From: [REDACTED]
To: [Gatwick Airport](#)
Subject: TR020005 – Gatwick Airport Northern Runway Project - Written Representation
Date: 11 March 2024 22:35:28

Issue Specific Comments on Surface Transport (Walking and Cycling)

Mole Valley Cycling Forum (MVCF) objects to this application as it stands, and wishes to make the following points:

Key walking routes within 2 km

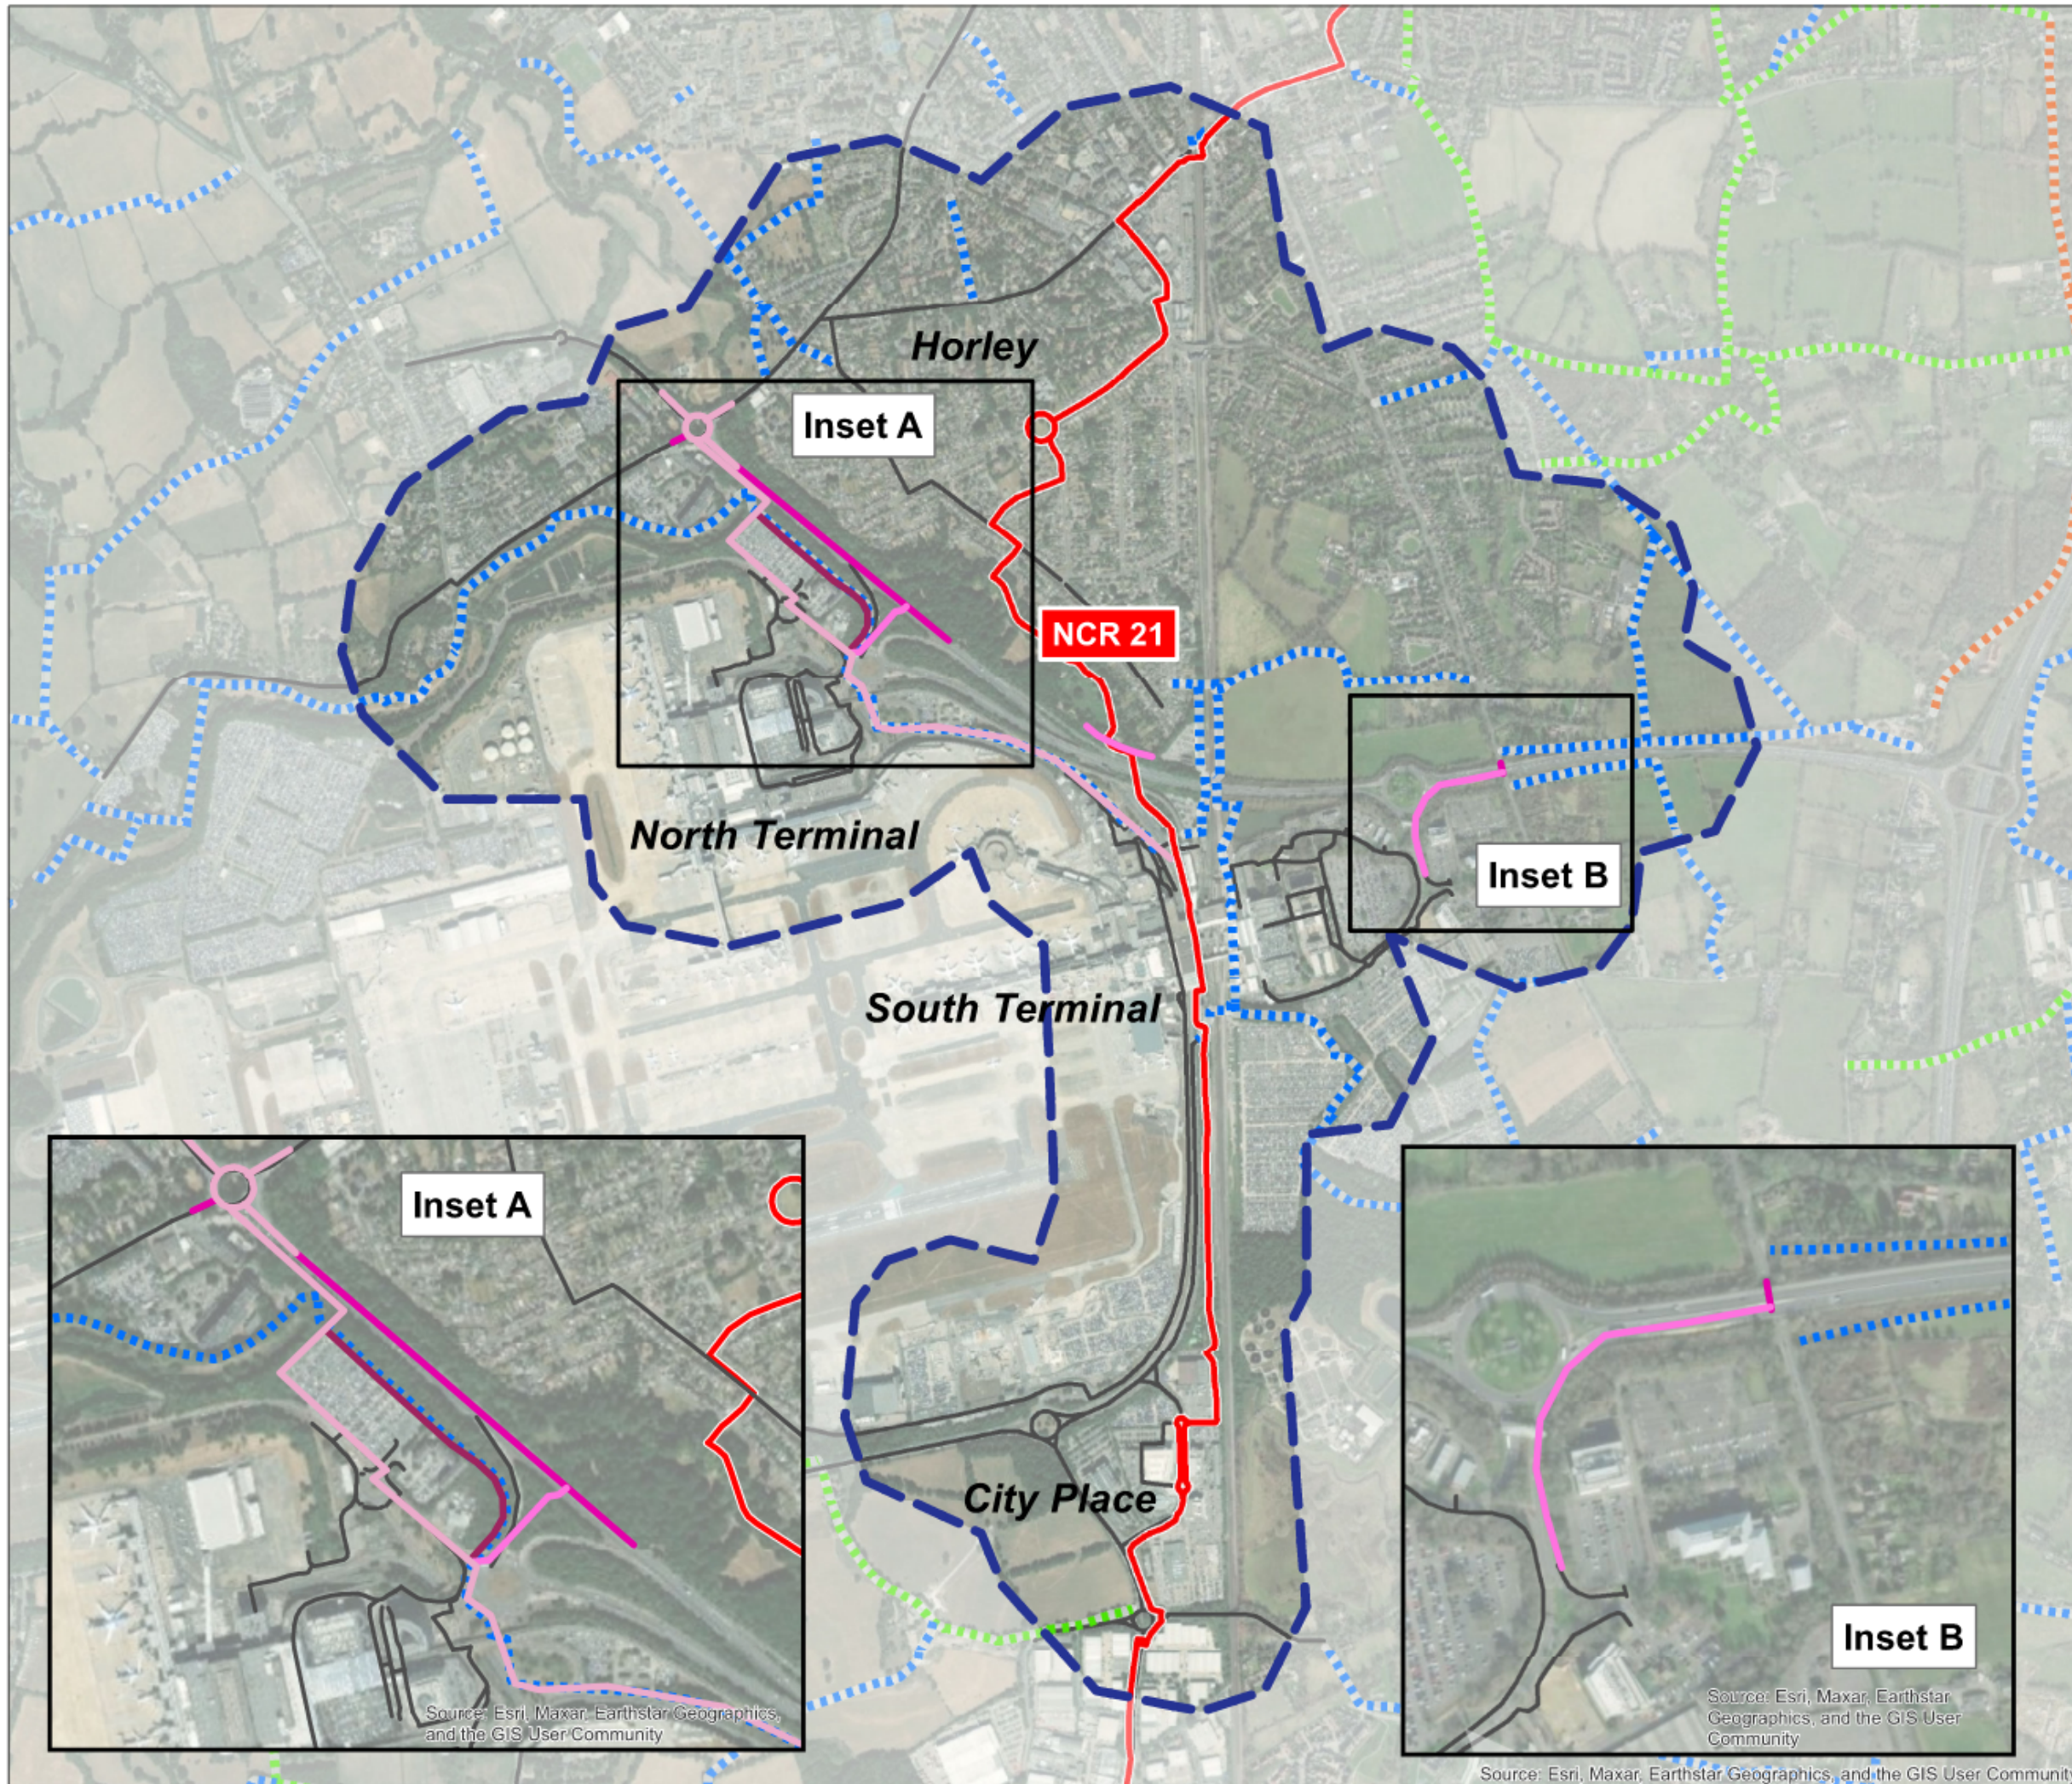
We also note with concern that the National Cycle Network Route 21 (which forms part of the Avenue Vert from London to Paris) and which passes through the airport from Horley to Crawley, has been omitted from all the maps provided.
